Formal Objection to Application Reference: BR/255/18/HH- 30 Mansfield Road.

Date: 04.11.18

Following the latest submission for planning permission at 30 Mansfield Road we write to you with the following comments as we would wish to formally object to the latest application/proposal.

ROOF PLANS

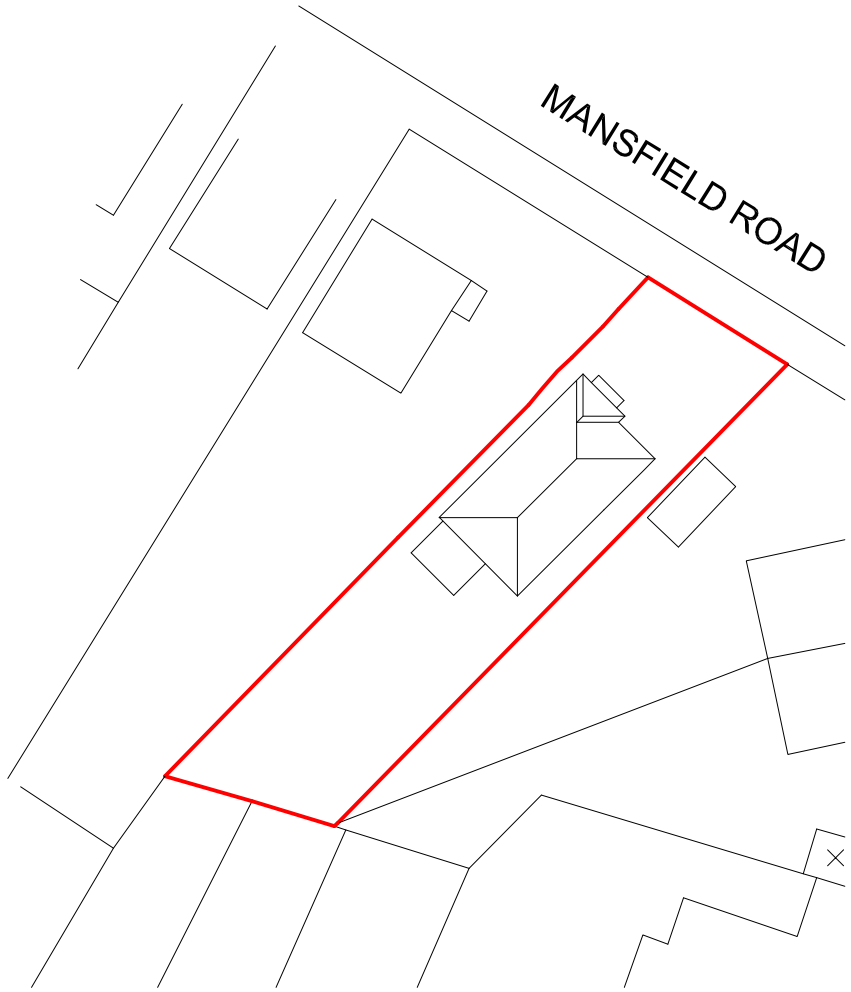
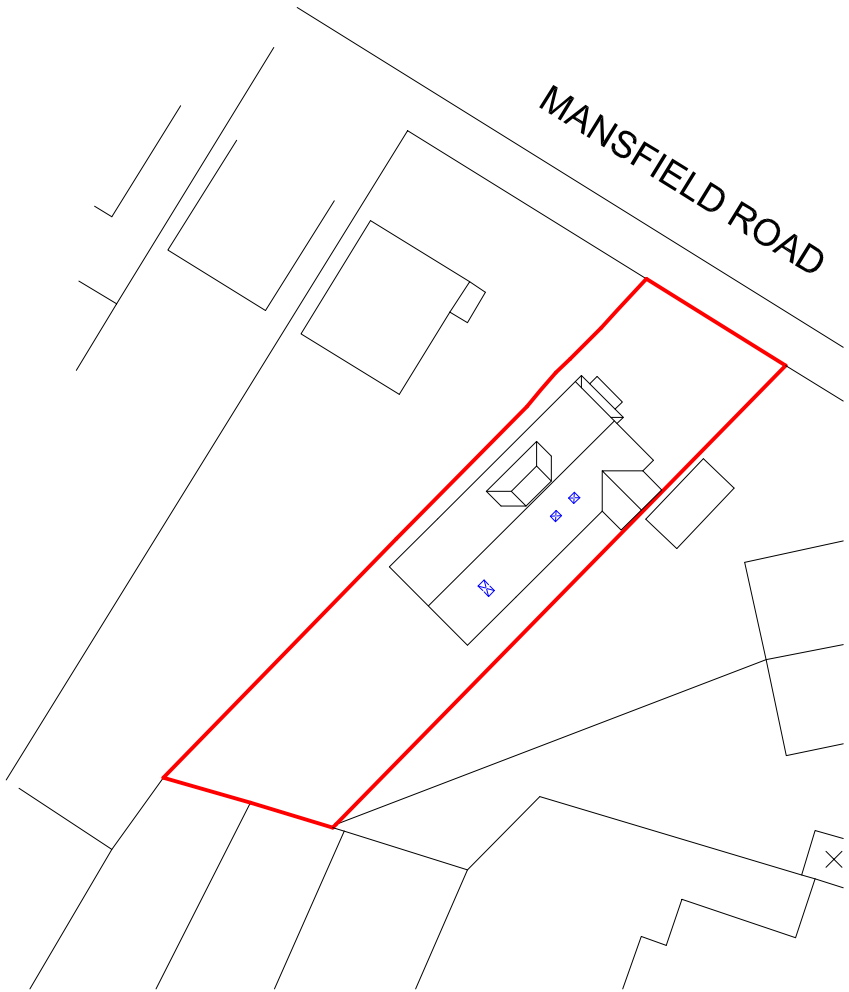
We would like it noted that had the applicant carried out the original development as approved under BR/305/17/HH then alongside the obscure glass and fixing shut of the dormer windows we would have considered the development to be in a reasonable form. However, with the height of the hip as proposed a strong impression was given that this roof was to be used as a sun terrace. This fear of the area being used in this way has lead the applicant to now apply for the full roof works, removing the site as a terrace but increasing significant mass and bulk instead.

In an ideal scenario we would have preferred a lower hip roof surrounding the ground floor extension to be reduced in height and a condition attached to this approval preventing the area to be used as a terrace and/or balcony. Or the design could have been altered under request of the Local Planning Authority to show a window instead of double doors and Juliet balcony. If this application, as hoped, shall be refused we would like the use of the roof to the ground floor extension restricted so it is not to be used as a terrace/balcony.

PROPOSED FIRST FLOOR PLAN

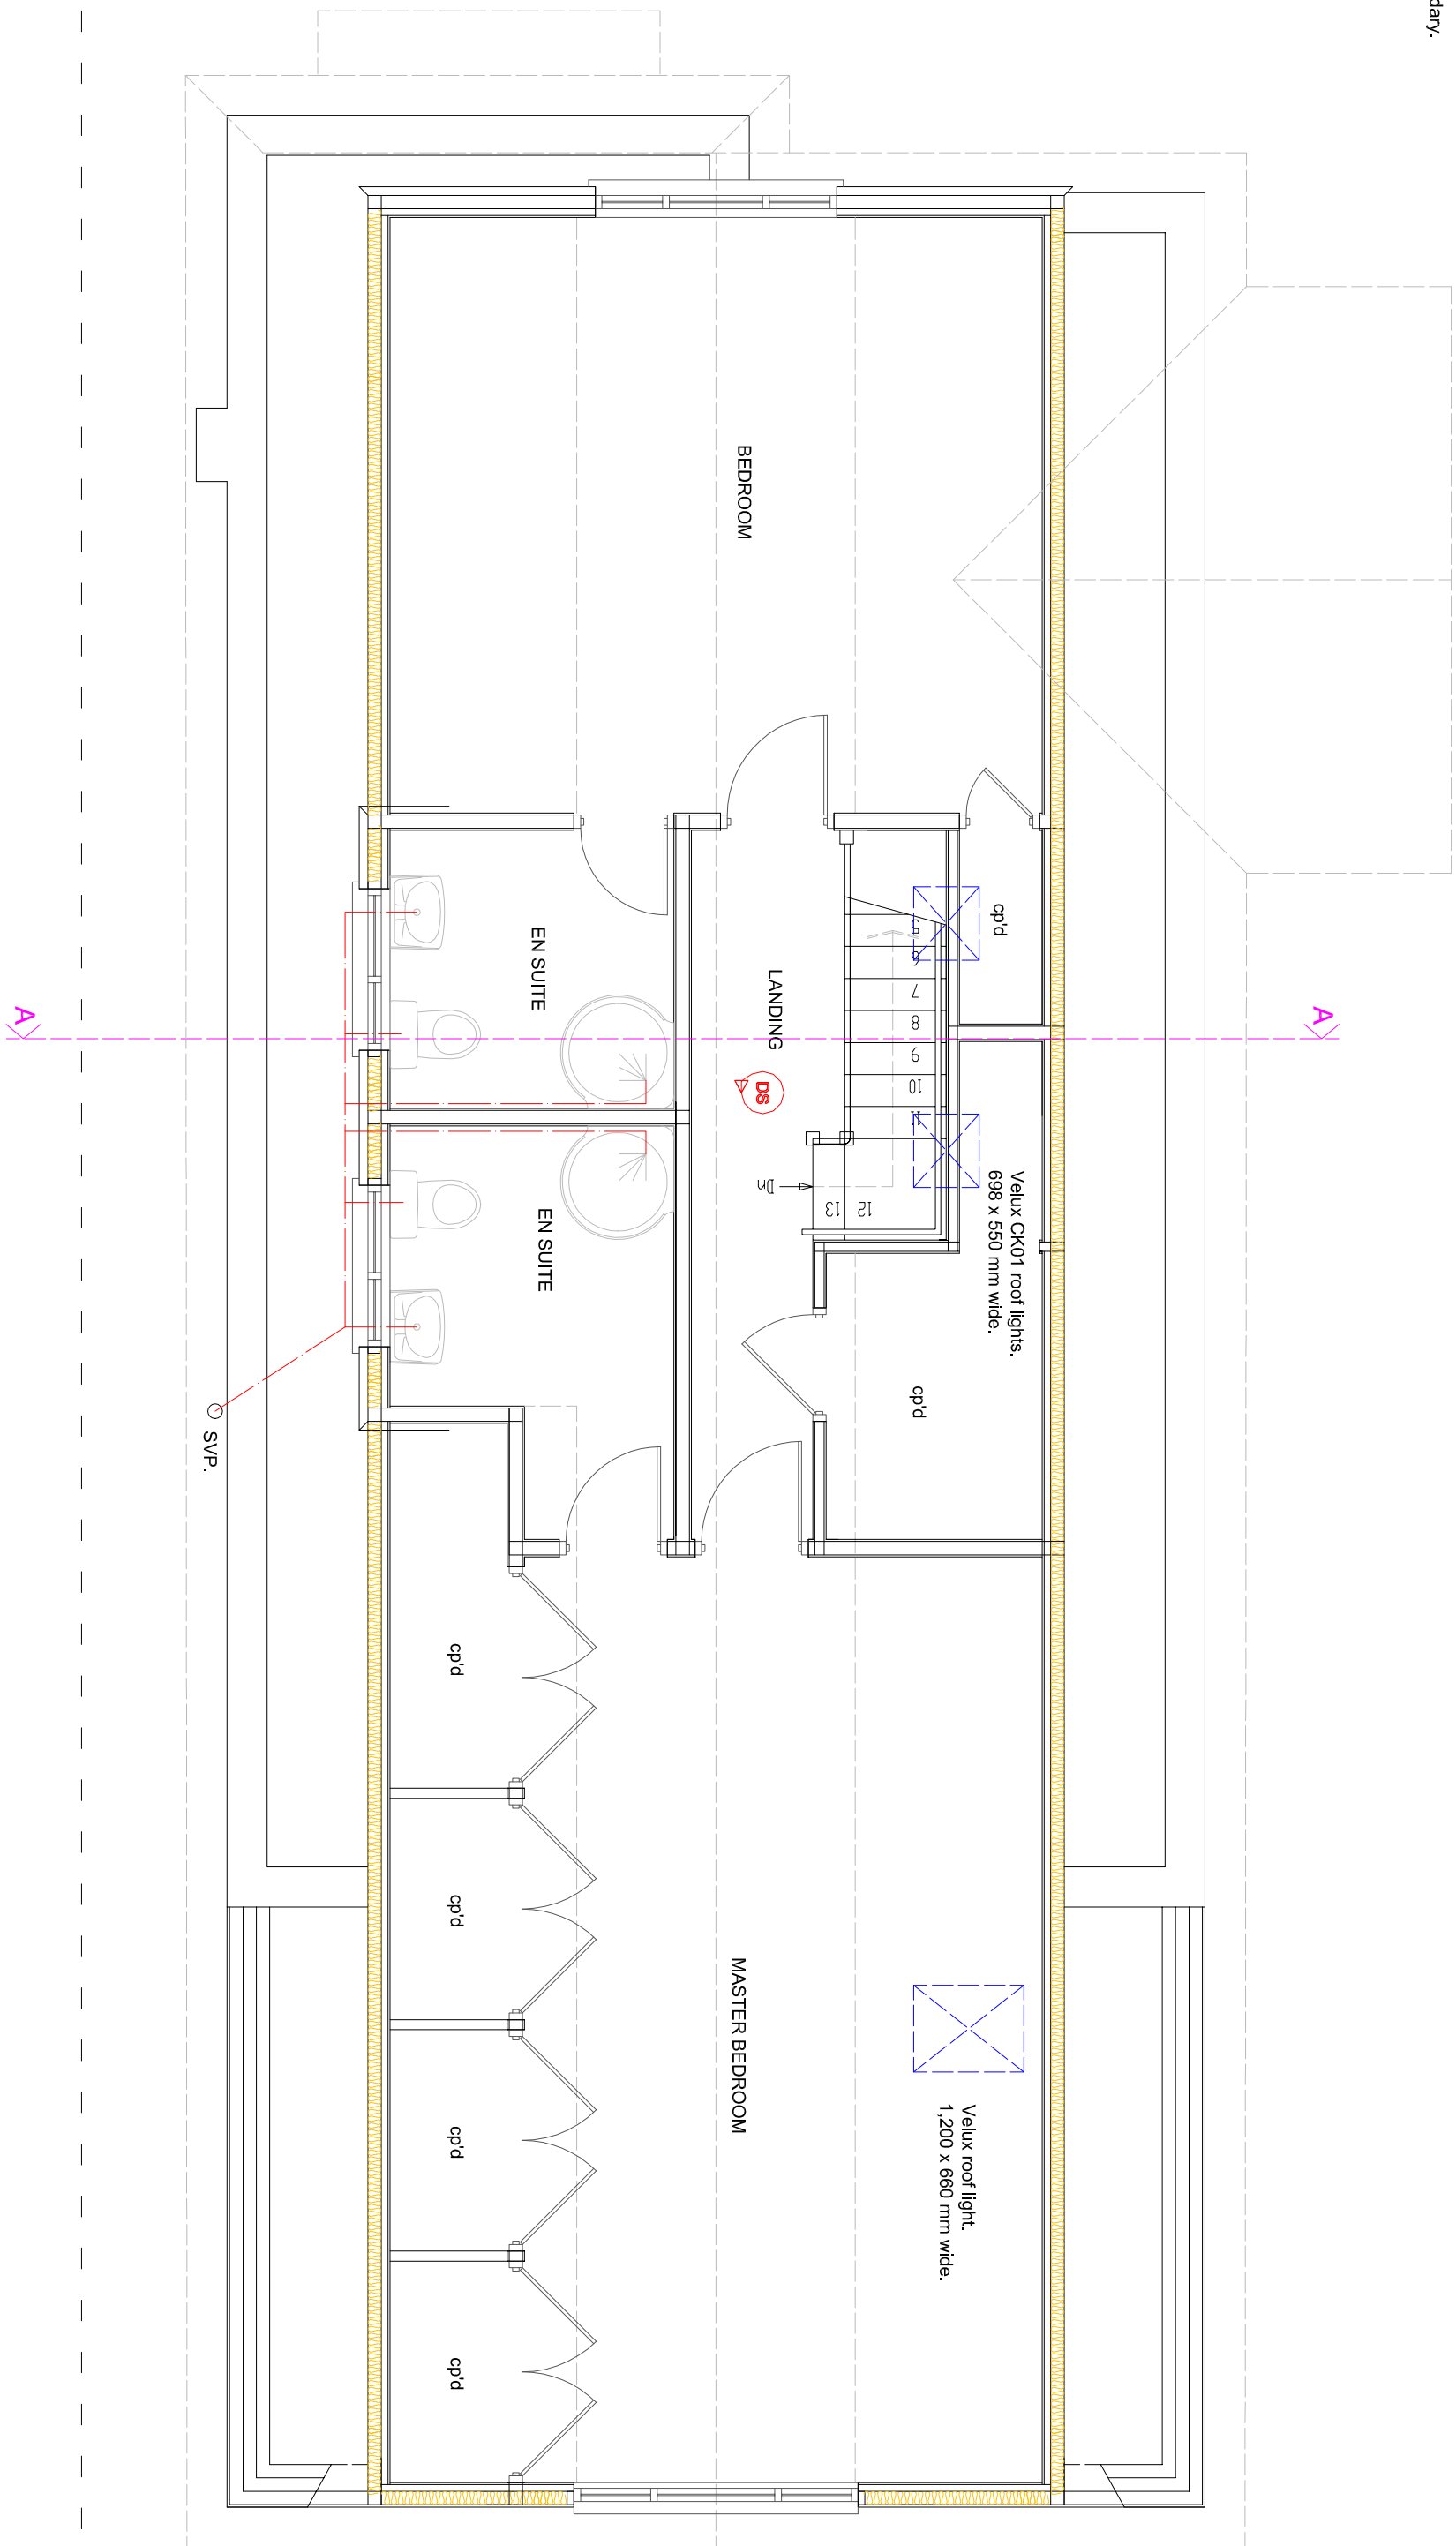
However this does not seem to have been carried out under both past applications and this development has now been completed. Although fitted with obscure glass there is strong concern that the windows are openable under 1.7m from the proposed finished floor levels which shall cause us to be over-looked and our privacy lost. Application BR/255/18/HH does not annotate or show anywhere with supporting statements that obscure glass and fixing shut these windows are proposed. Therefore we would ask the case officer to seek clarity on this, have the plans updated and condition this either to be done, retained, or carried out retrospectively under a modest timeframe. We would appreciate an update on this prior to any formal determination of the application and do not consider that windows fitted with obscure glass but openable protect our privacy levels sufficiently. The windows must be fixed shut also.

It has caused a dis-trust between neighbours and caused significant stress and anxiety throughout. It is considered that a much smaller scale development could achieve a generous bedroom size at first floor without the need for the overly large bedroom with substantial cupboard space which at a cost results in the poor and bulky design of No 30 and causes a significant adverse impact to neighbouring dwellings. Therefore we ask that any case officer takes a detailed and sensitive approach to assessing the plans to ensure that the applicant is applying for all the works required to ensure a deviation or alteration from proposed plans does not occur in future.

PROPOSED ELEVATIONS

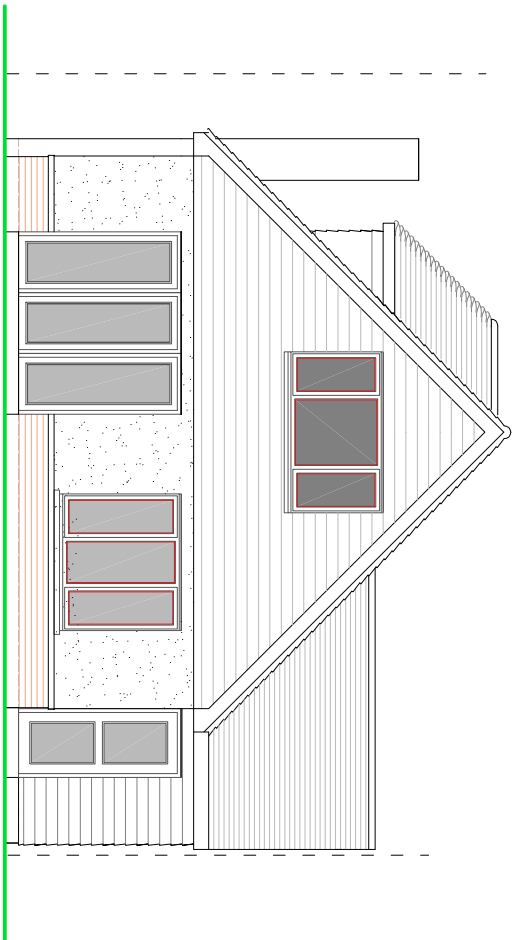
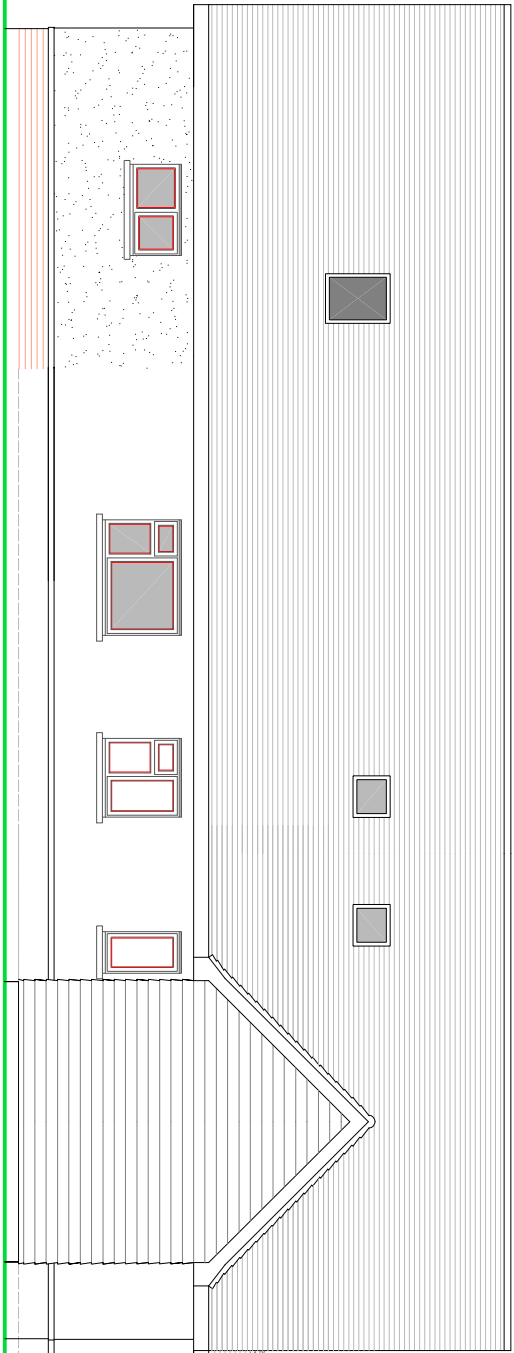
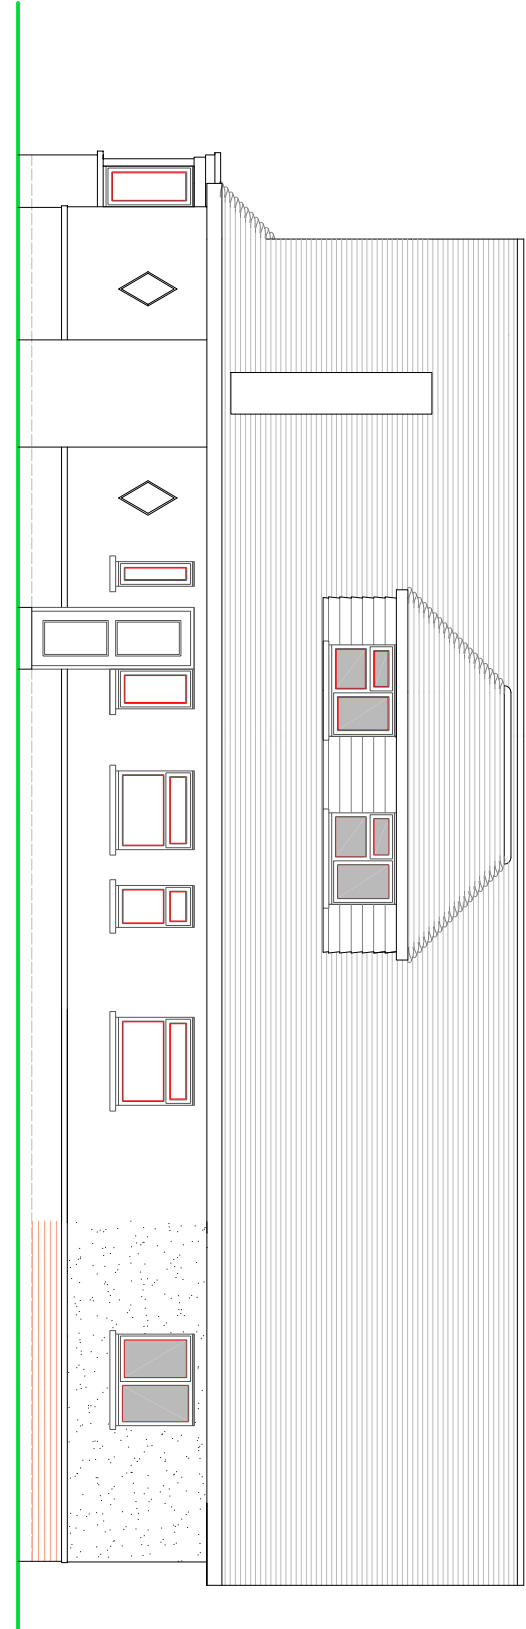
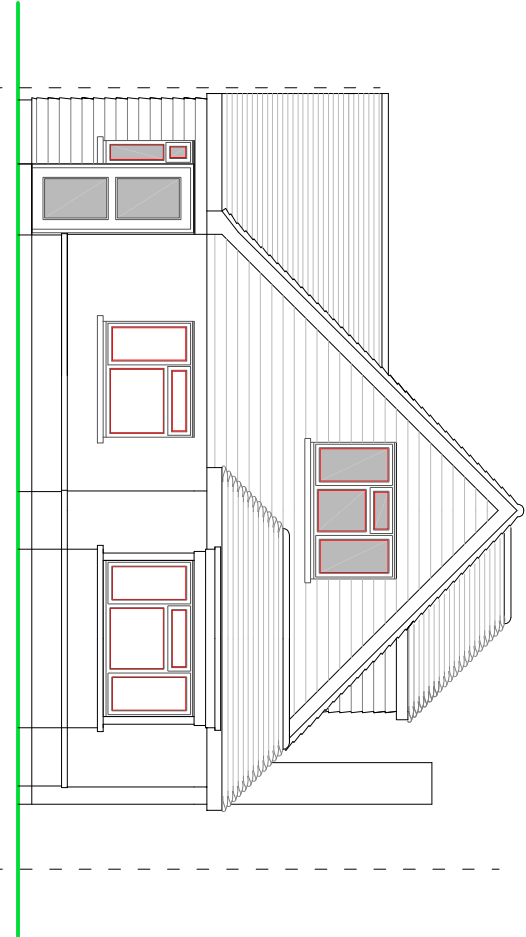
which requests that two storey extensions are set away from shared boundaries by more than 1 metre. Something that is not achieved in this proposal.

It is our belief that the roof finish to the ground floor rear extension was never for cosmetic purposes but to use the area as a sun terrace via the Juliet doors.
